File No: SSD 7484 MOD 7
Our Ref: R/2014/39/P

State Significant Development SSD 7484 (MOD 7) – 23-33 & 33-35 Bridge Street, Sydney

SCALE @ B1	DRAWN	APPROVED	FIRST ISSUE DATE
1:20	PH	DR	10/12/19
PROJECT CODE	SHEET NO	REVISION	
19050	SP-DA-G-4102	5

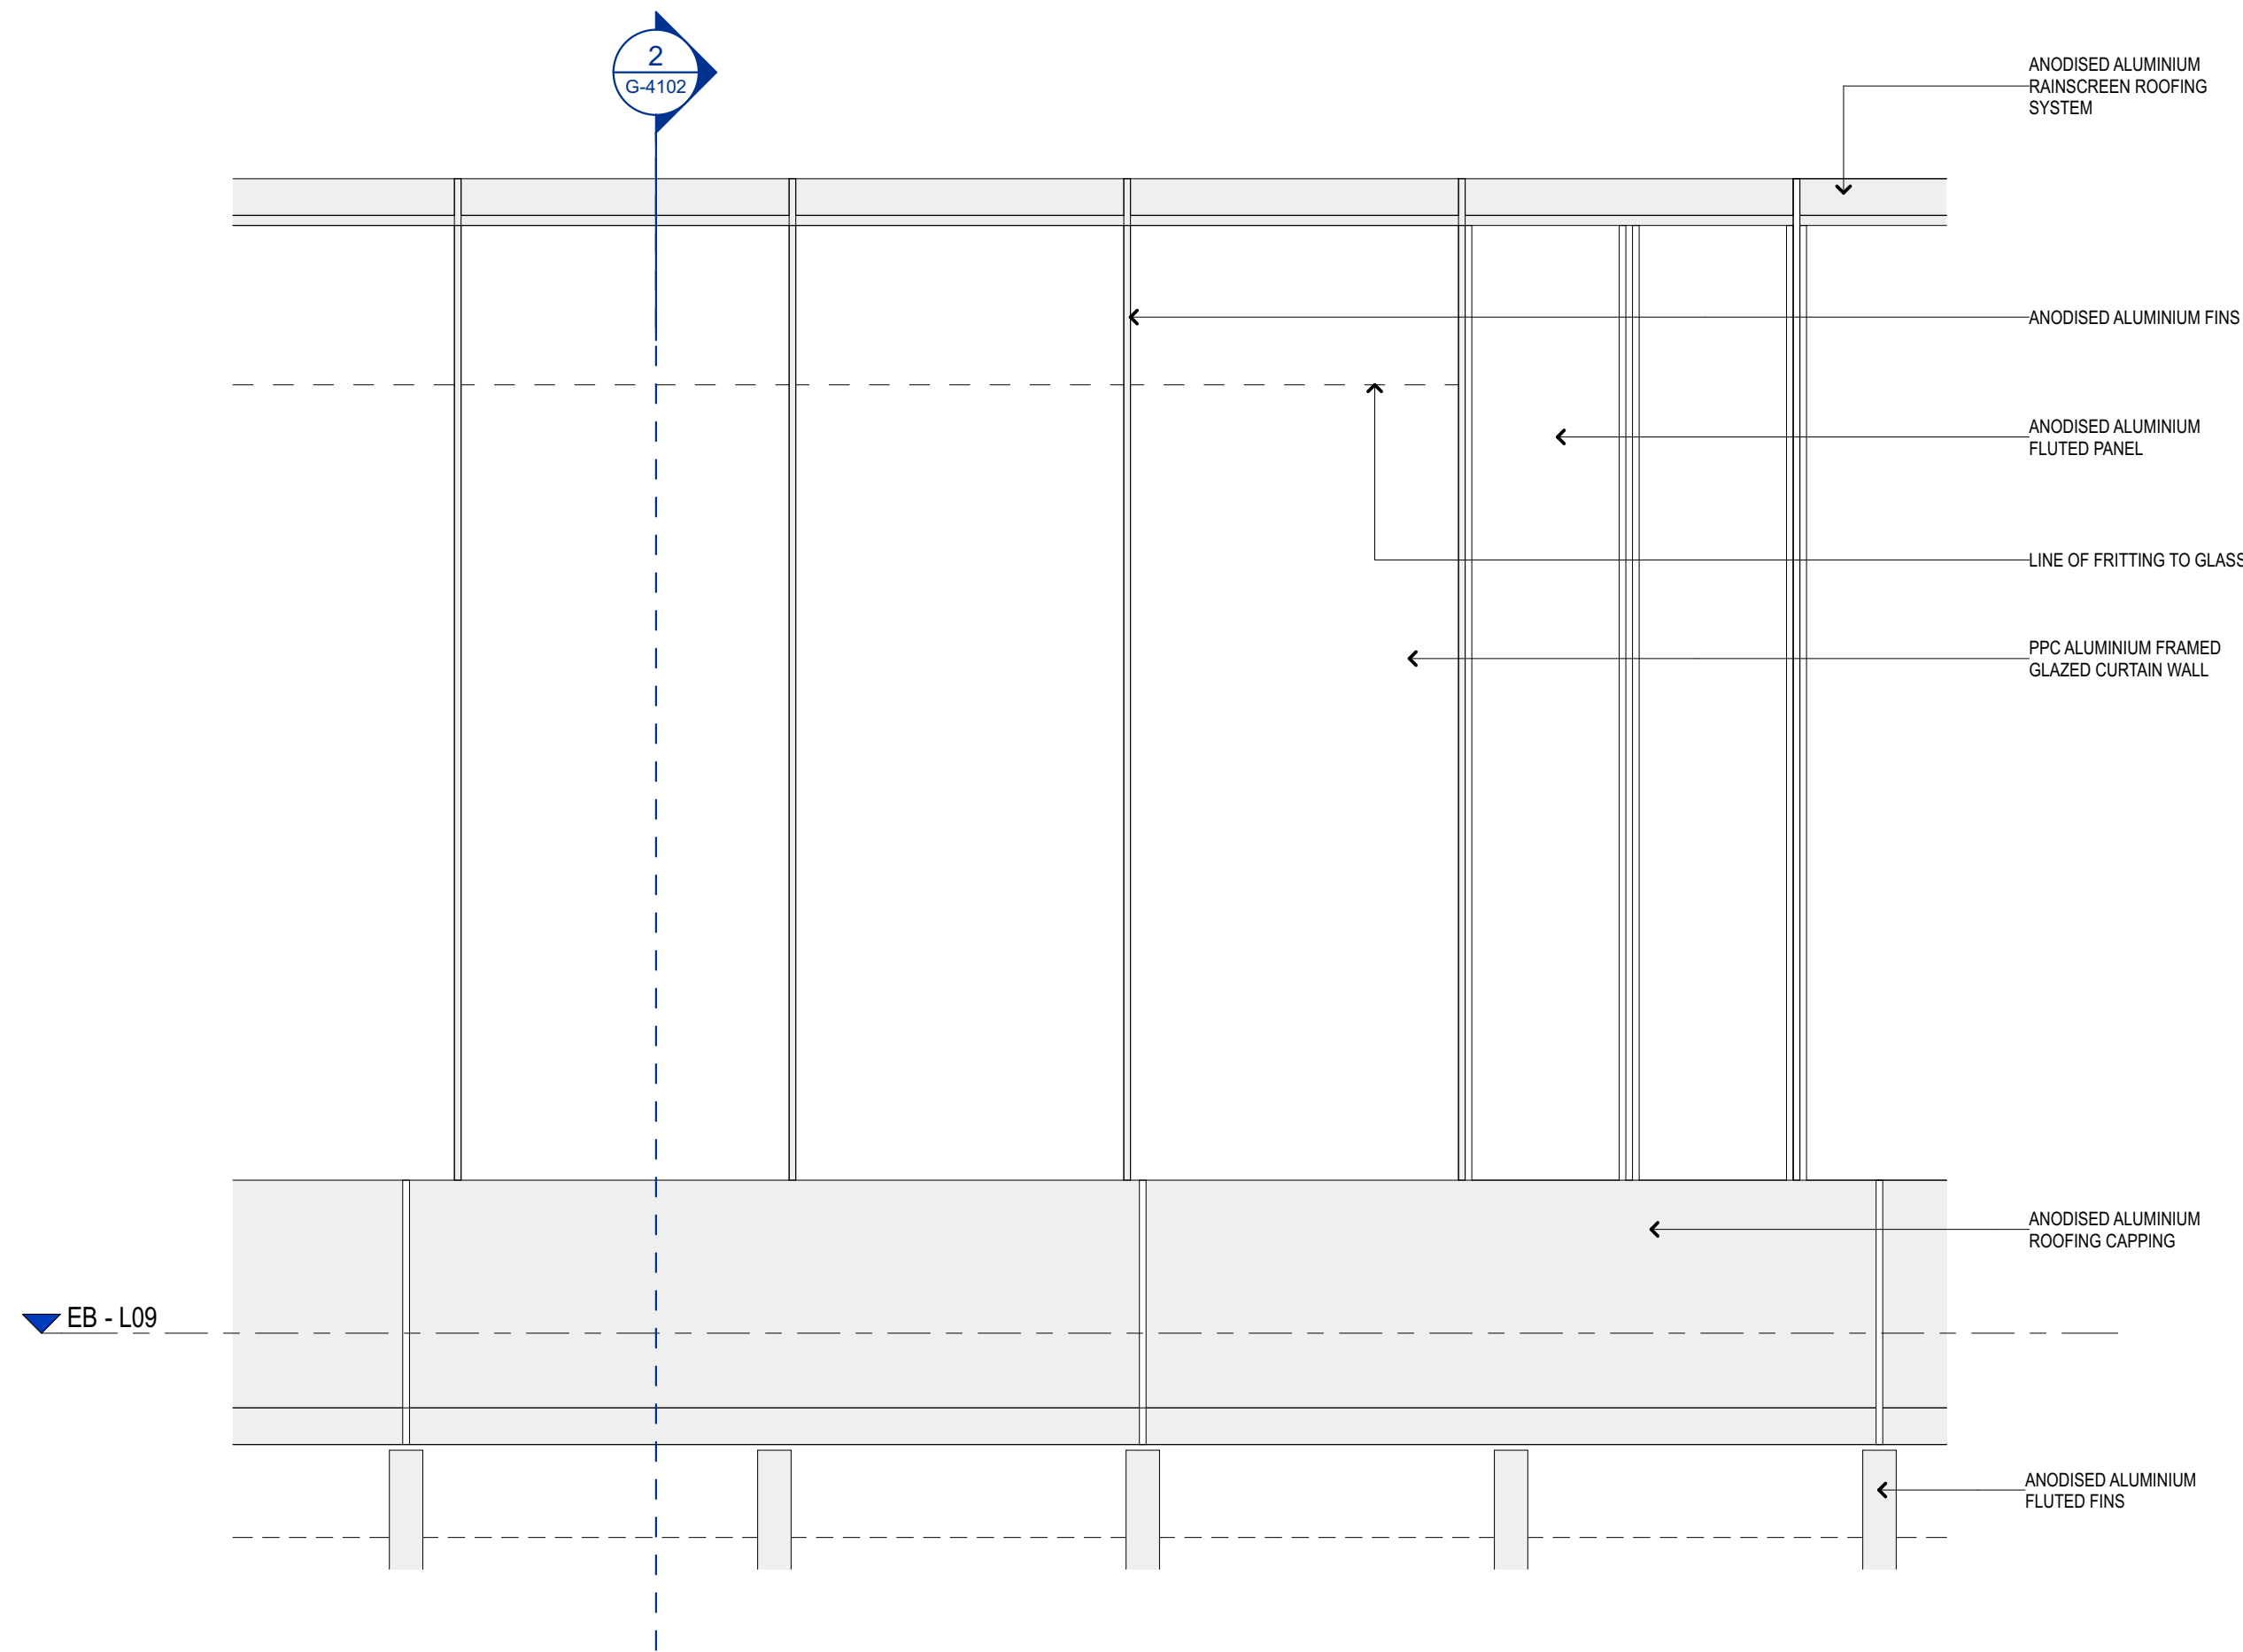
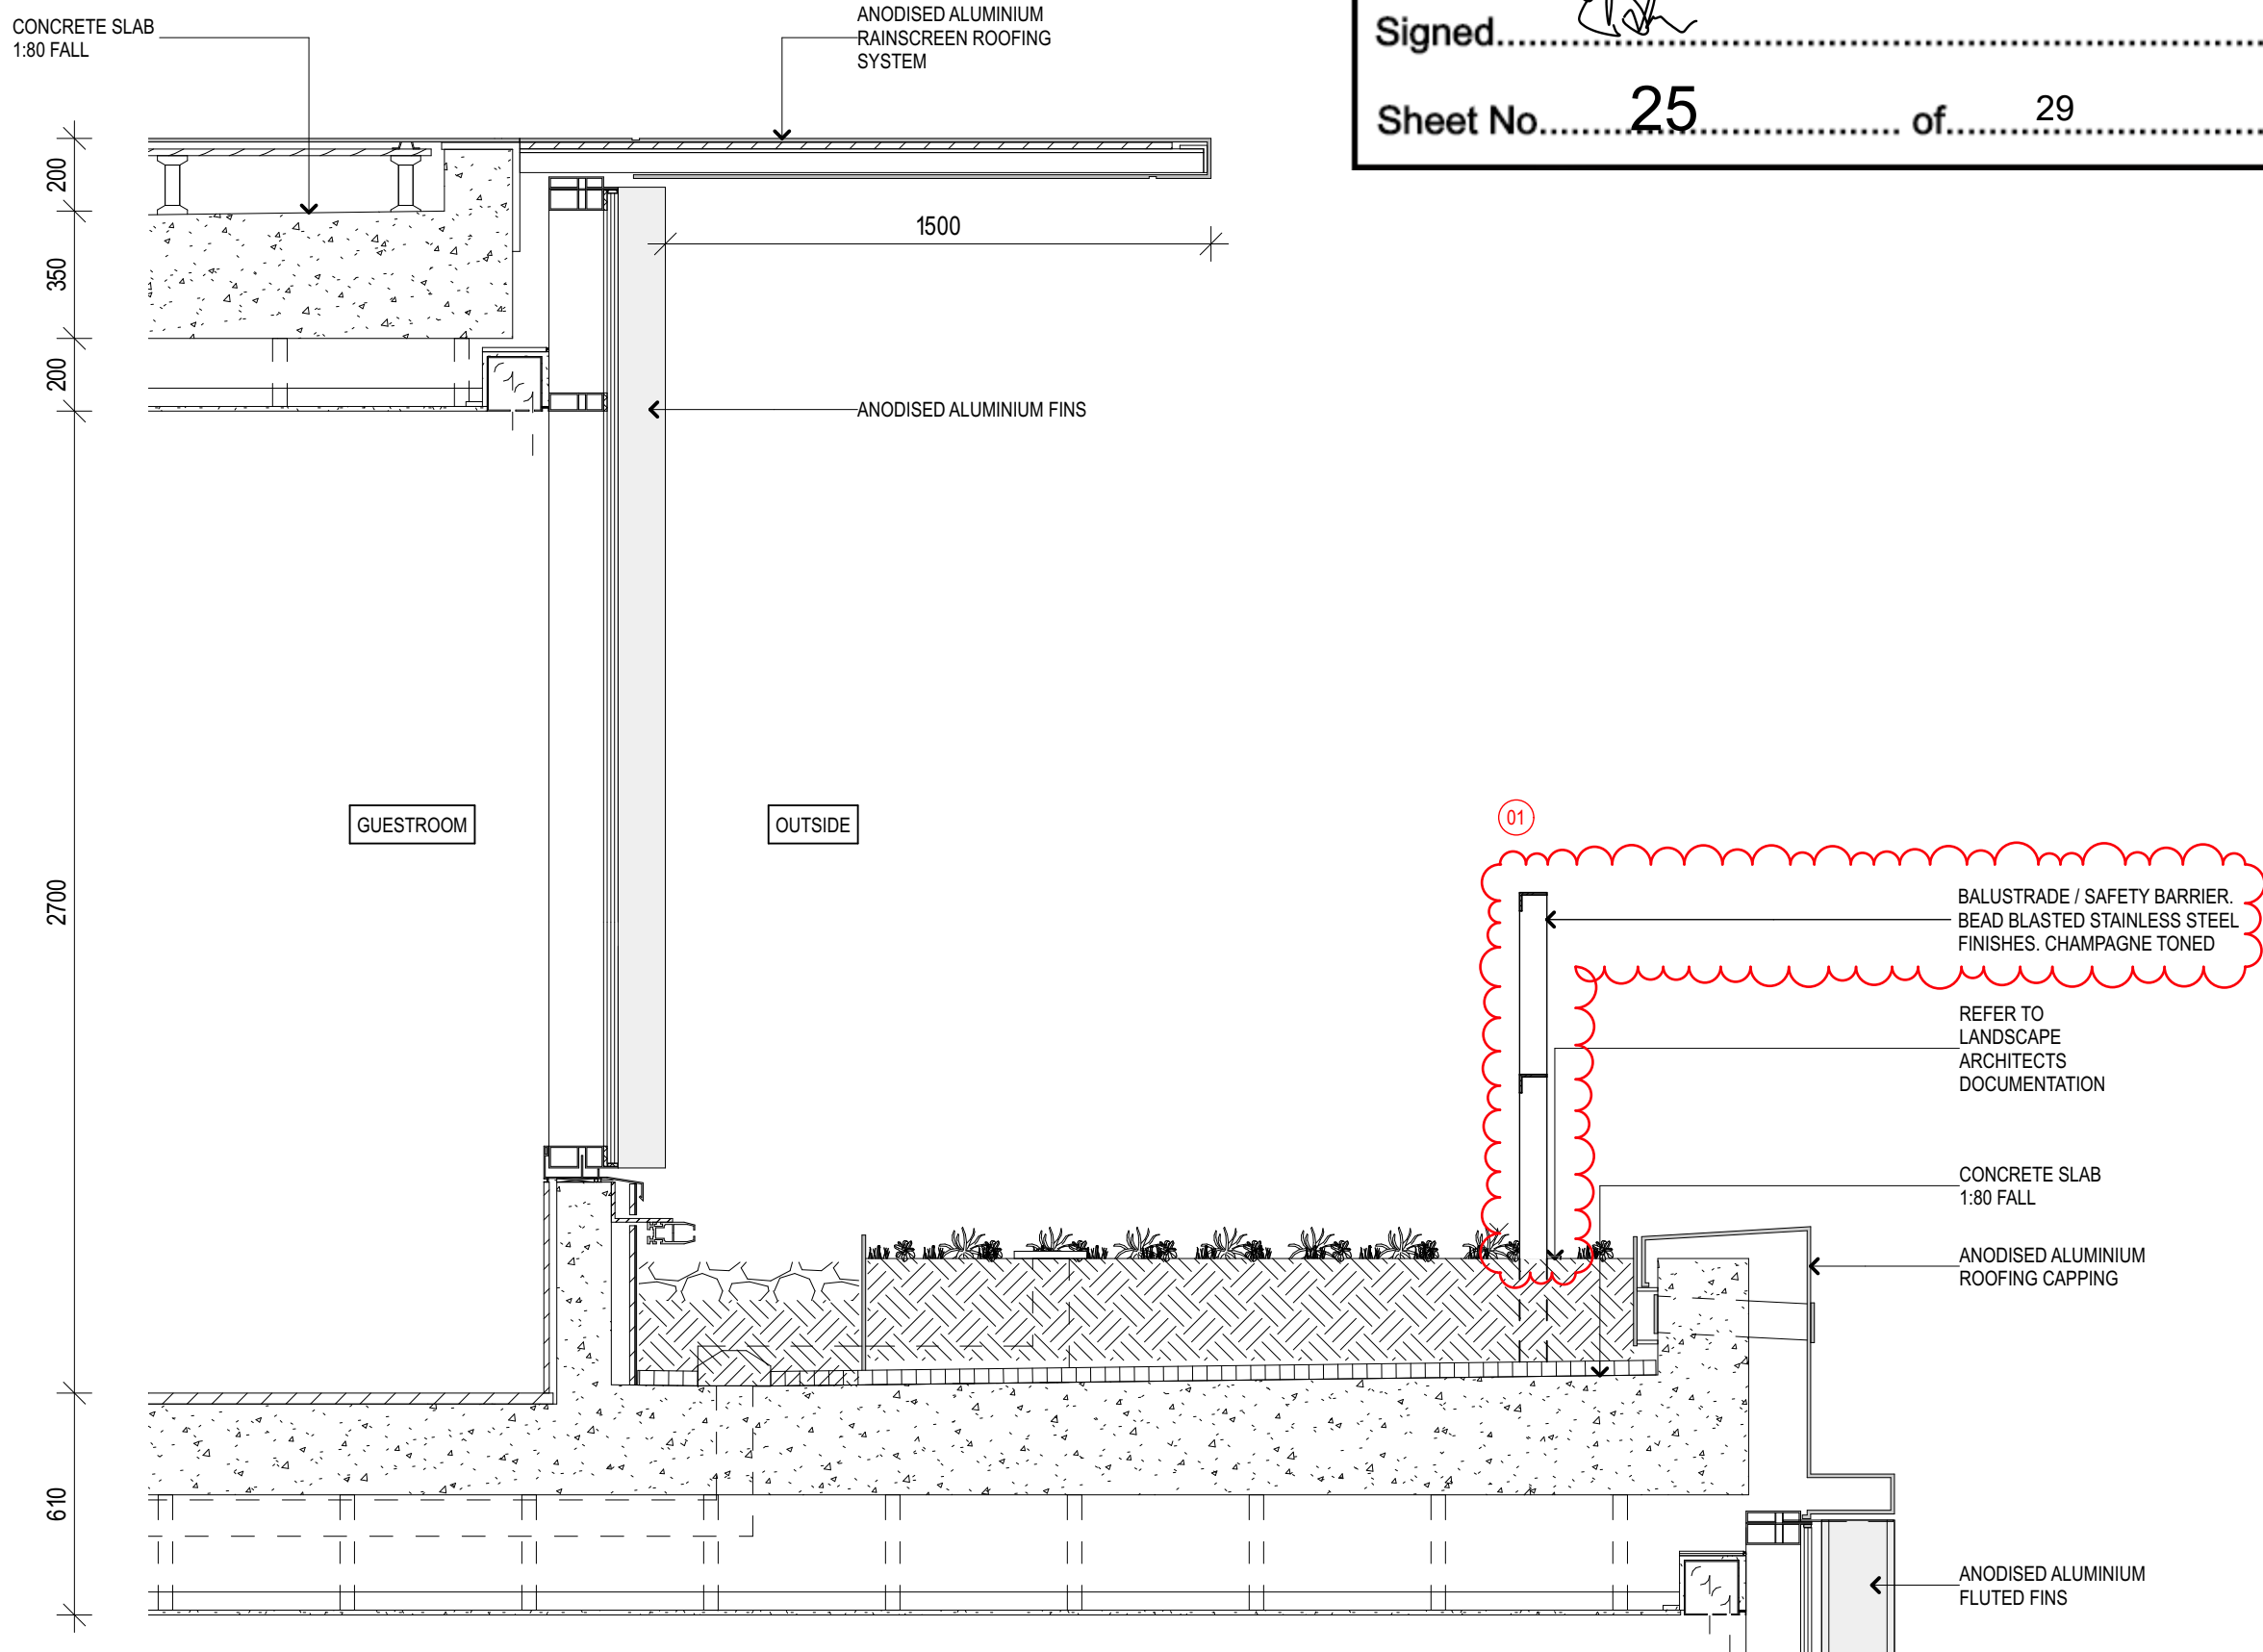
A new balustrade to the top of the southern section of the new addition (seen in the 1:200 sections and elevations) is assumed to facilitate safe and regular maintenance of the adjacent landscaped green roof, rather than for outdoor space for guests. This should be repeated on the detailed sections such as drawing SP-DA-G-4102.
